PCD Project Manager_2026-06-10_008 - Architectural Elevations.pdf Markup Summary

Subject: Callout
Page Label: AS501 - SITE DETAILS
Author: dsdparsons

HONOR CHARTER SCHOOL BUILDING CORPORATION HONOR CHARTER SCHOOL CONSTRUCTION DOCUMENTS

AS101

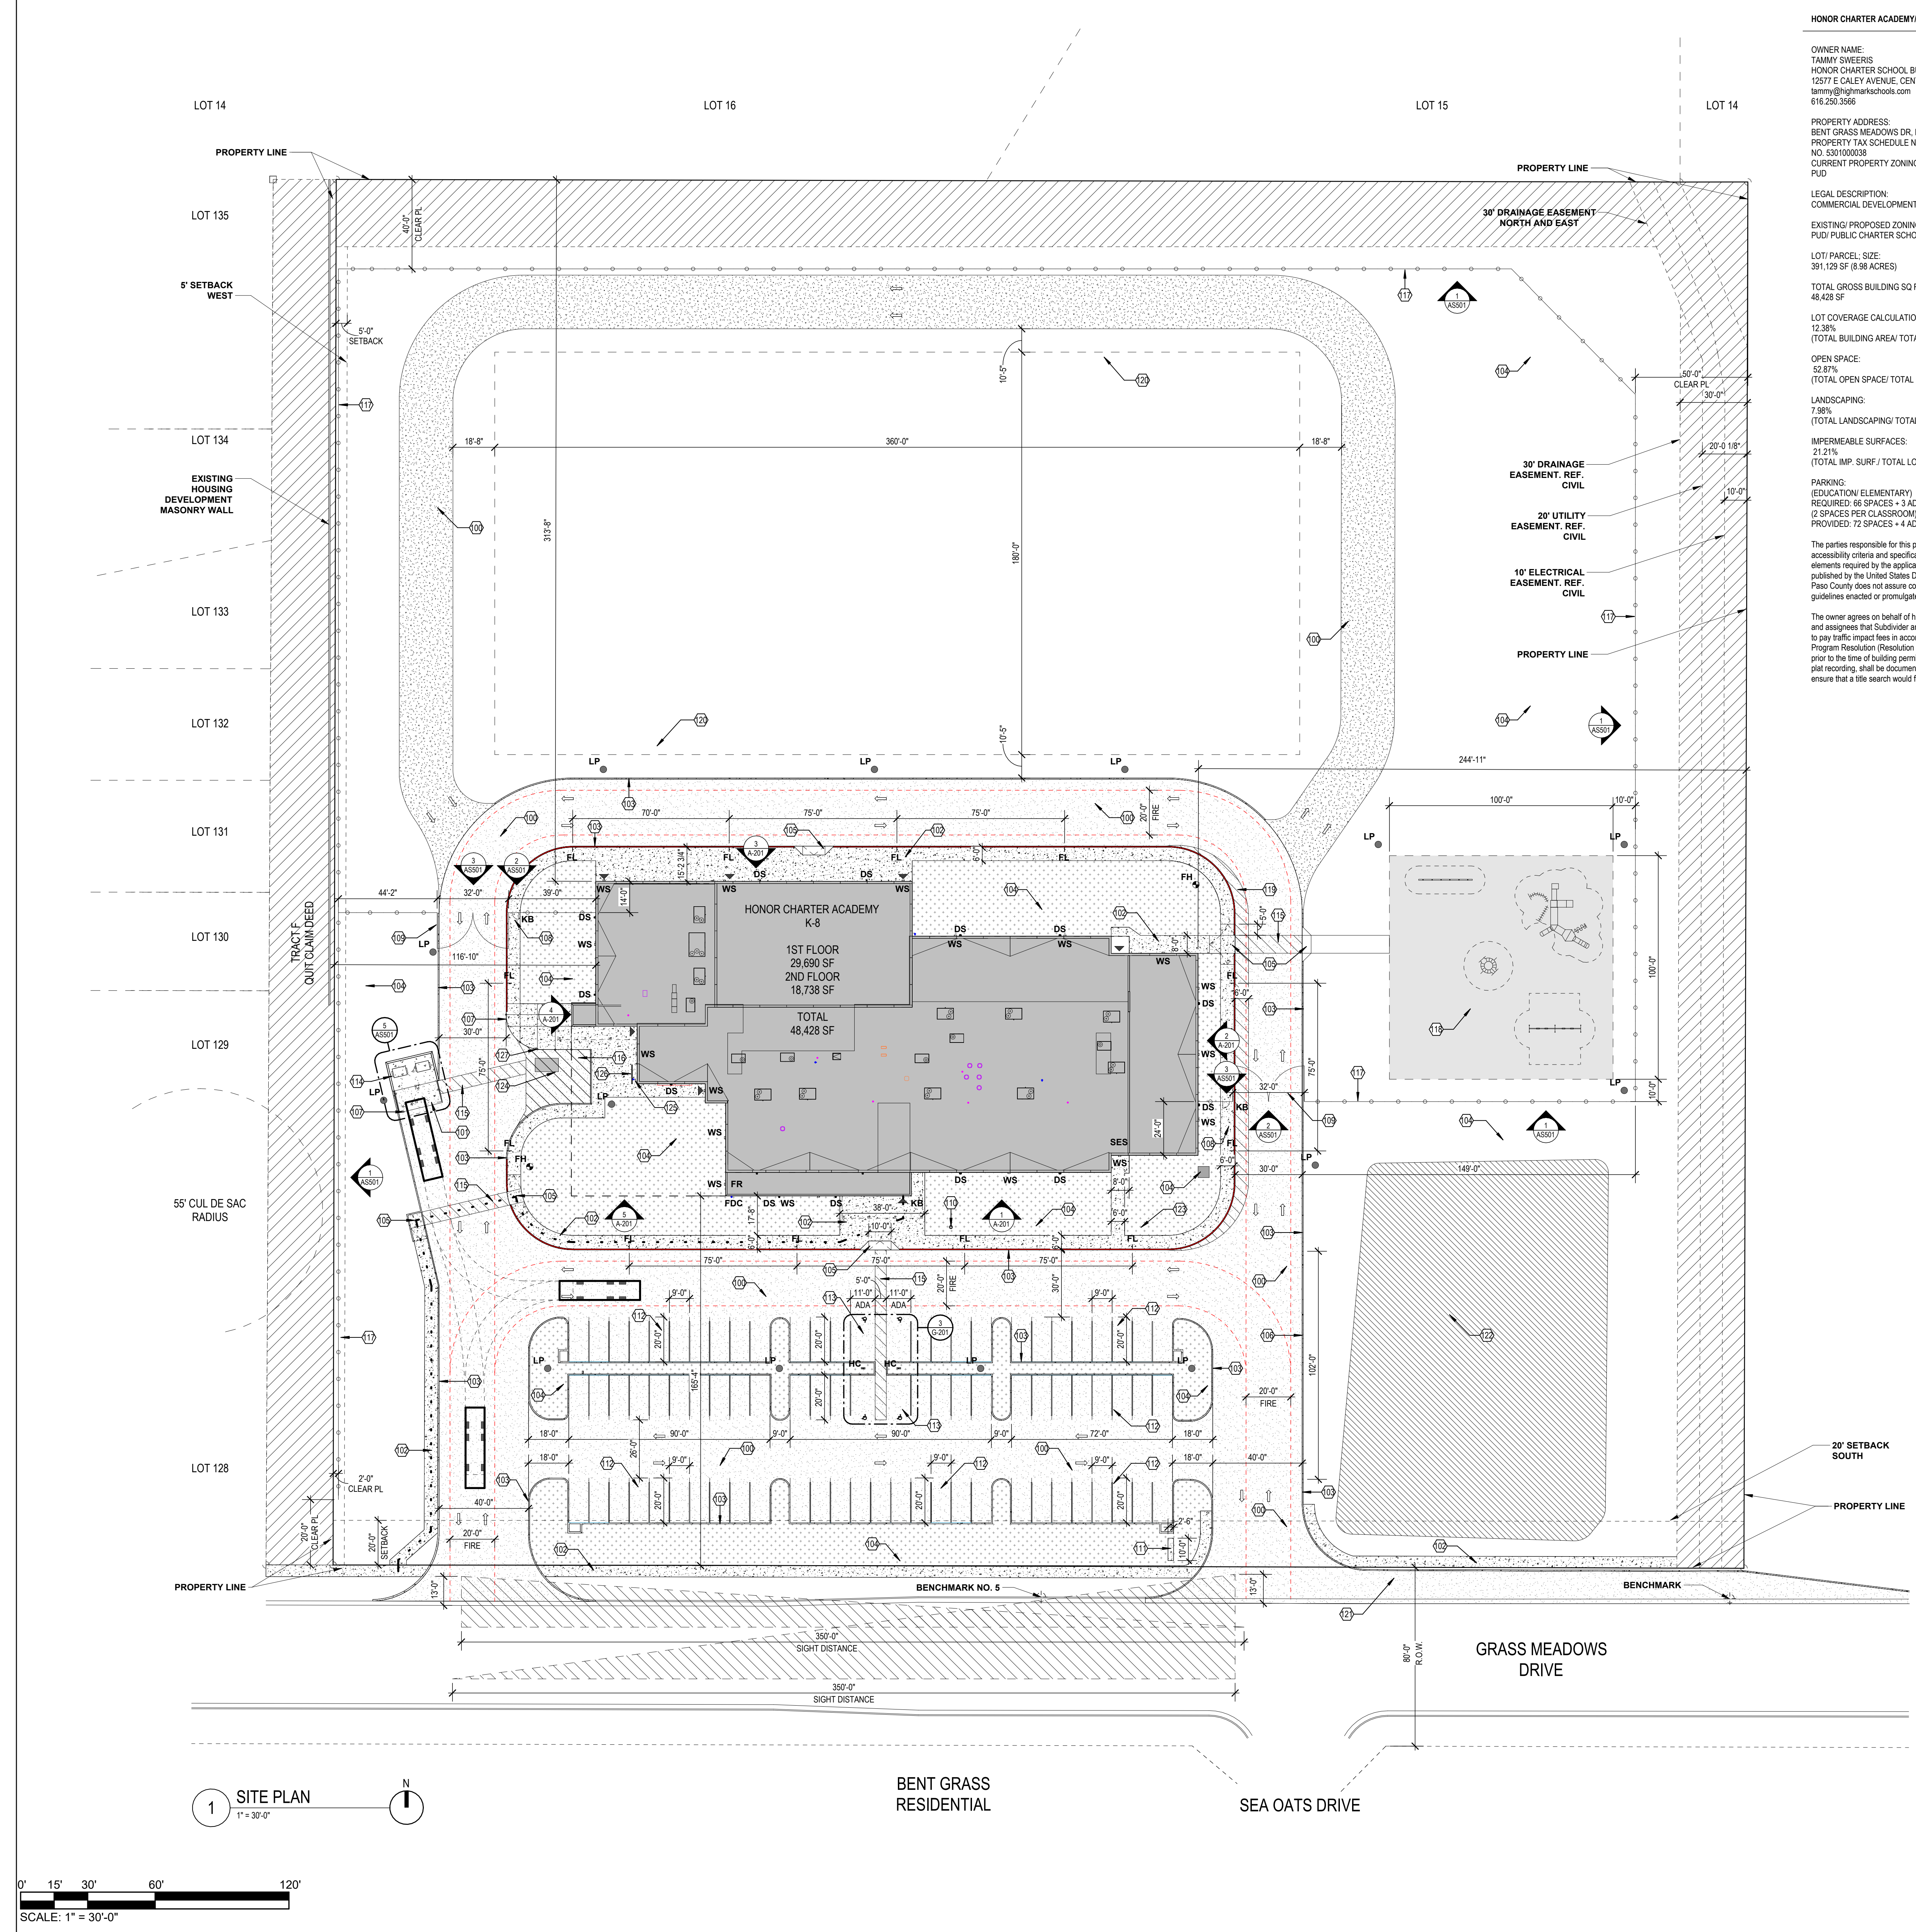
are there any sports fields,
bleachers , screening
walls/fences/ playgrounds

FIRE ACCESS/ KNOX BOX LOCATIONS ARE IDENTIFIED AT BOTH VEHICULAR GATES, AND THE MAIN ENTRANCE ON SITE PLAN SHEET AS101.

THERE WILL BE A DEDICATED PLAYGROUND STRUCTURE WITHIN THE SECURED AREA FENCE, EAST OF THE MAIN DRIVEWAY. PLAYGROUND EQUIPMENT WILL BE PROVIDED BY A SEPARATE VENDOR, NOT DESIGNED BY THE ARCHITECT. PLEASE REFER TO AS101 FOR PROPOSED PLAYGROUND LAYOUT. ALSO REFER TO ATTACHED PLAYGROUND EQUIPMENT VENDOR DOCUMENTS FOR ADDITIONAL INFORMATION.

THERE ARE NO ADJACENT OCCUPIED PROPERTIES TO THE NORTH OR EAST. THERE IS AN EXISTING MASONRY SCREENWALL AT THE WEST PROPERTY LINE WHICH SCREENS THE ADJACENT RESIDENTIAL DEVELOPMENT (IDENTIFIED ON SHEET AS101).

CHAIN LINK FENCING WILL BE PROVIDED AROUND THE PROPERTY (AS SHOWN ON SHEET AS101). CHAIN LINK PRIVACY SLATS WILL BE ADDED TO THE CHAIN LINK FENCE AT THE SOUTHEAST PROPERTY LINE (BEGINNING WHERE THE EXISTING RESIDENTIAL MASONRY SCREEN WALL ENDS/ TO THE SOUTH PROPERTY LINE). PLEASE REFER TO SITE DETAILS SHEET AS501 FOR FENCING ELEVATIONS AND DETAILS.
